Consultation Response from KC, Highways Development Management
2023/91408 Land adj, 21, Thomas Street, Lindley, Huddersfield, HD3 3JJ
Erection of care home (Class C2) with sub-station, associated car parking, access, servicing, landscaping and other associated works
Date Responded: 10-July-2023. Responding Officer: Mark Berry Responding Ref: 2-20SE-4

Drawing Title  
Proposed Site Plan

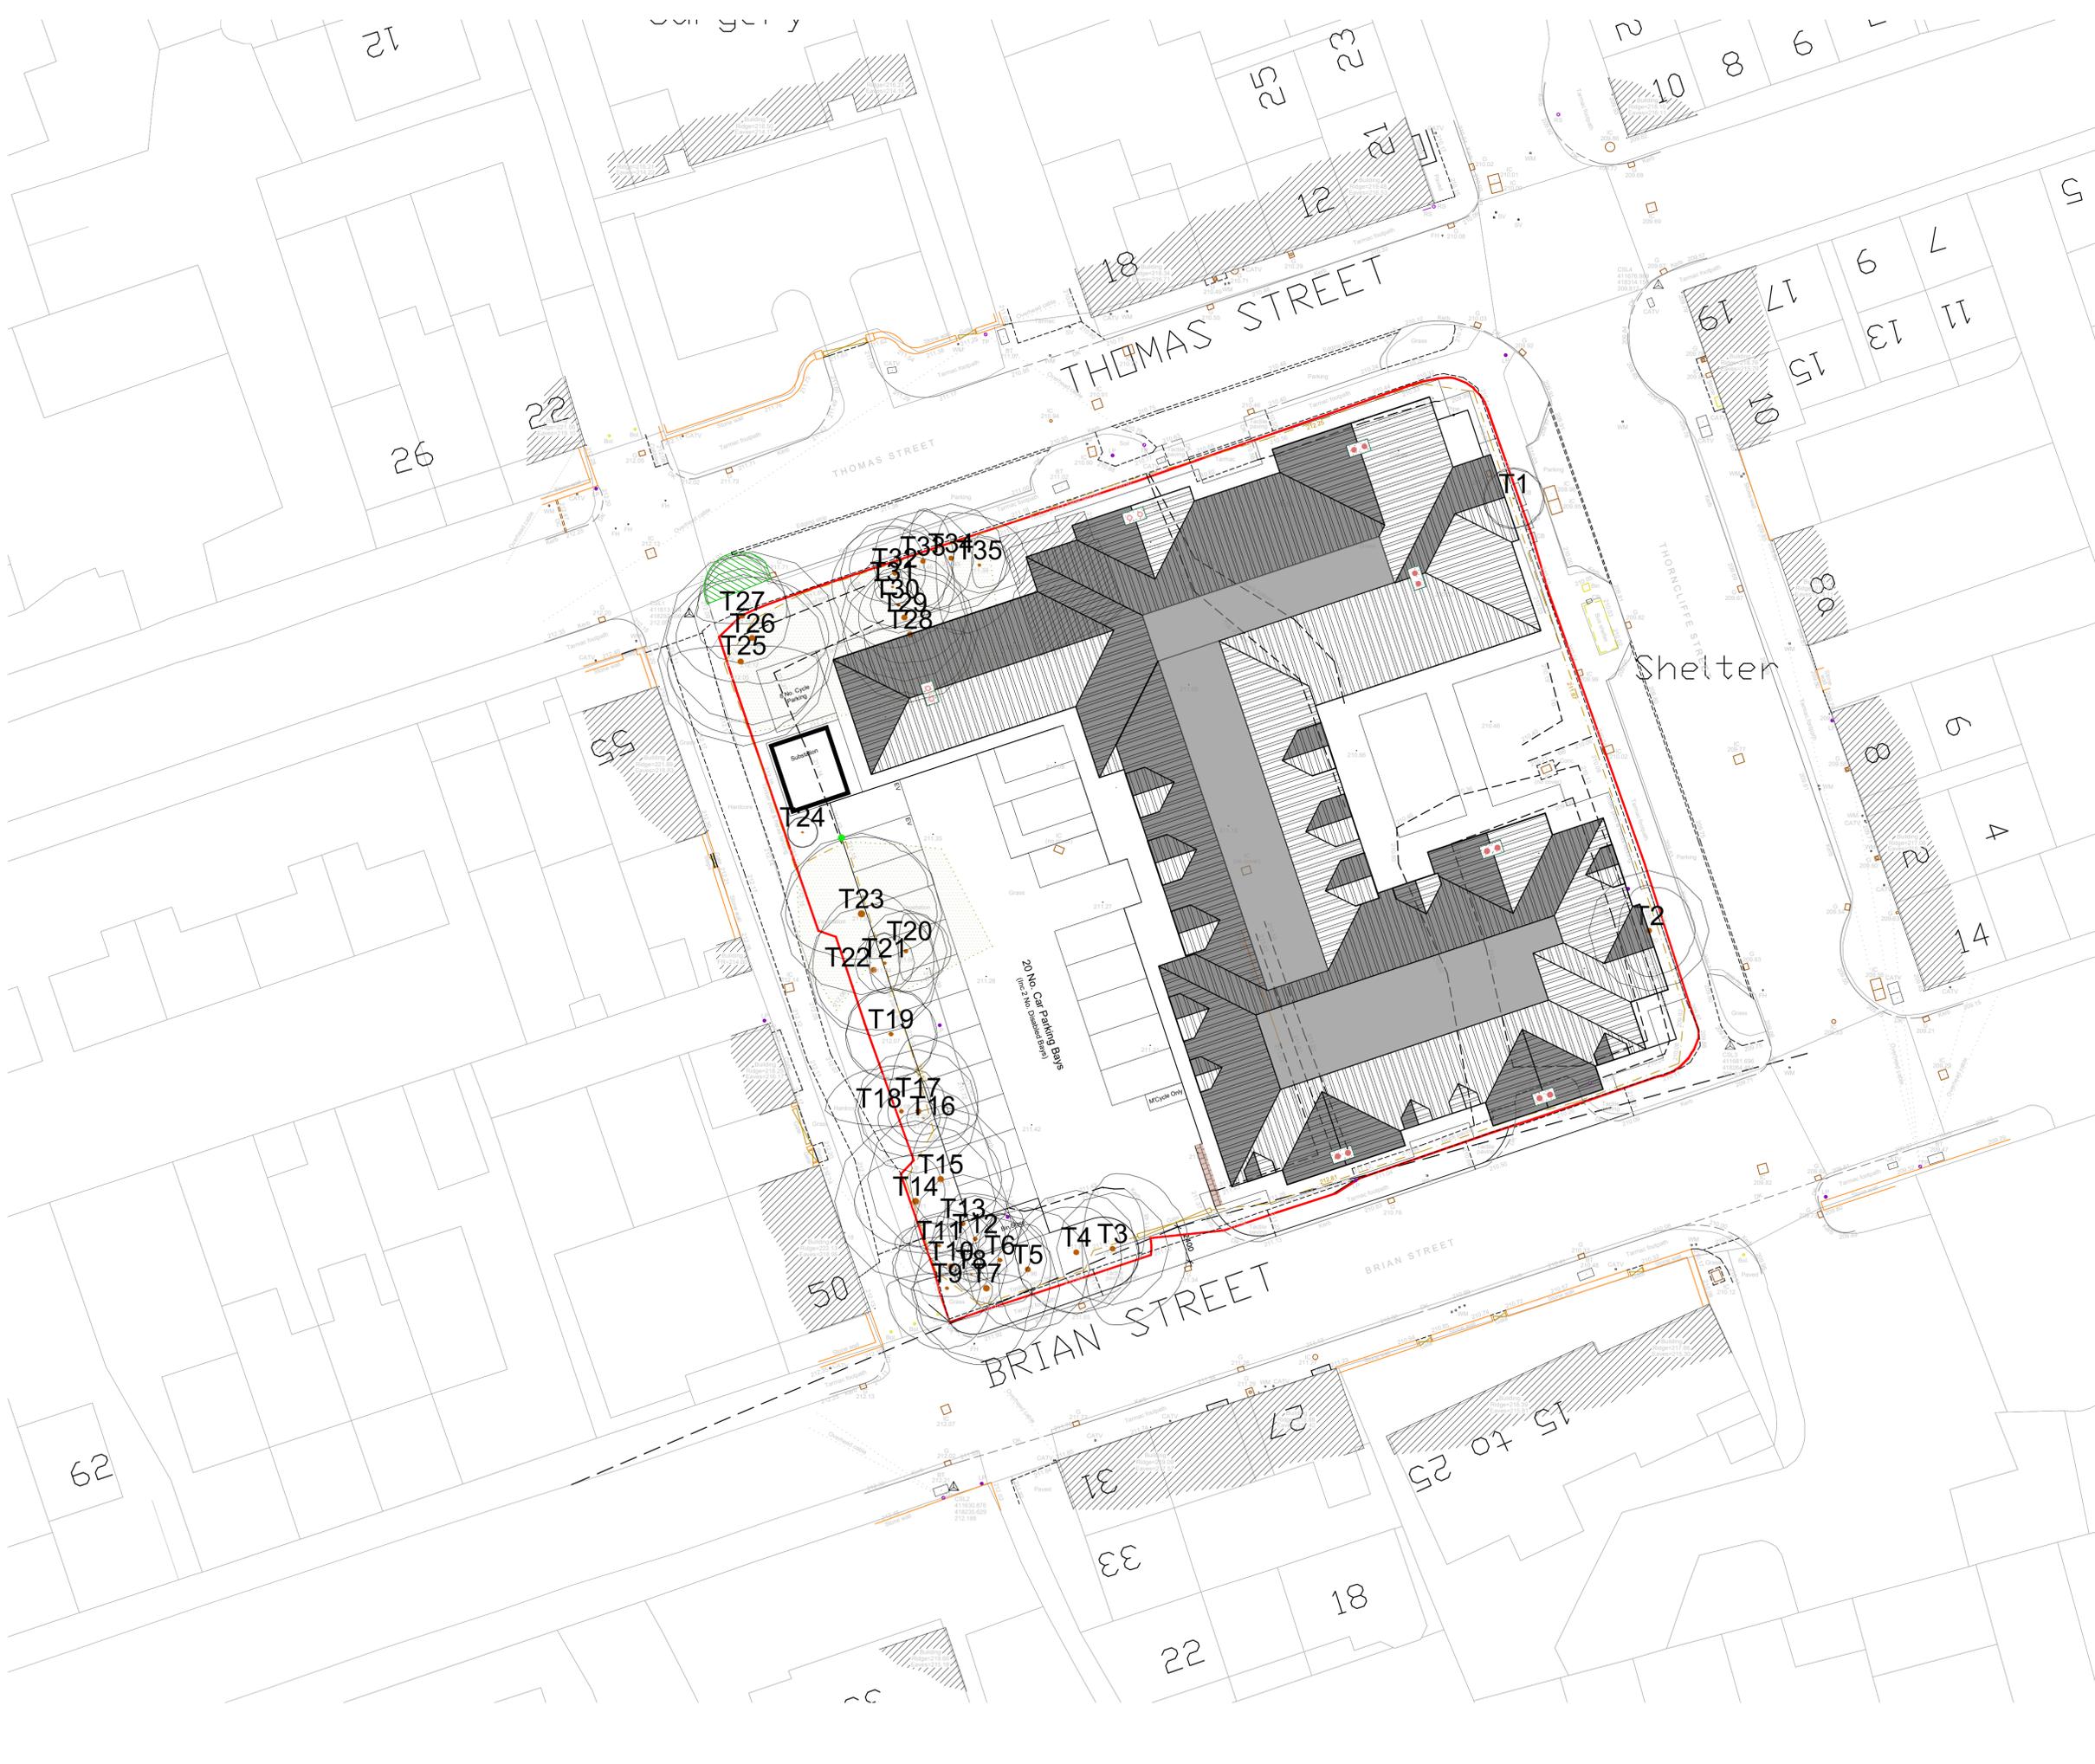
Vehicular access to the site is proposed from an improved site access located on Brian Street towards the western end of the site frontage, in the vicinity of one of the former accesses to the site. A dropped kerb pedestrian crossing will be provided at the site access bell mouth and incorporating tactile paving.

There is on street parking on Brian Street and the Highway Authority have raised concerns that visibility from the access could be affected by vehicles parked on street. The Highway Authority consider that measures to manage parking would be required on Brian Street at either side of the site access. Drawing 152986-001 at Appendix C shows the access visibility with parking measures (with details to be agreed with the Council) on the north side of Brian Street and extending 13.5m to the east of the access and 10m to the west of the access. Worst case on street parking is shown indicatively with visibility shown to approaching vehicles to the east and west of the access between parked cars.

The development will reduce the number of vehicular site accesses from 3 to 1, with the access on Brian Street to the east of the site frontage and the access onto Thomas Street becoming redundant. The redundant accesses will be permanently removed and reinstated as footway within the highway boundary.

Refuse collection is proposed kerbside from Brian Street with the refuse vehicle standing on the waiting restrictions at the site access. A 6m x 3m service bay is shown provided within the car park adjacent to the main entrance to facilitate all other regular daily servicing from an off-road position. Swept path assessment of a minibus and an ambulance servicing the site using the service bay has been undertaken which demonstrates that regular service vehicles can access and egress the site in forward gear.

The development shall not commence until a scheme detailing measures to manage parking on Brian Street to either side of the side access and all associated works, together with appropriate Safety Audits has been submitted to and approved in writing by The Local Planning Authority. Unless otherwise agreed in writing no part of the scheme shall be brought into use until the approved scheme has been implemented.

Before development commences, the sightlines from the Brian Street access of 2.4m x is 32.8m to the east and 30.3m to the west as shown on the Sanderson Associates Visibility at site access plan number 152986-001 shall be cleared of all obstructions to visibility exceeding 1 m in height and these shall be retained free of any such obstruction.

No part of the development shall be brought into use until the existing accesses from Brian Street to the east of the site frontage and the access onto Thomas Street have been permanently closed [and any redundant footway crossings removed, and the footway reinstated] and the new access has been constructed and brought into use in accordance with details that have previously been approved in writing by the Local Planning Authority.
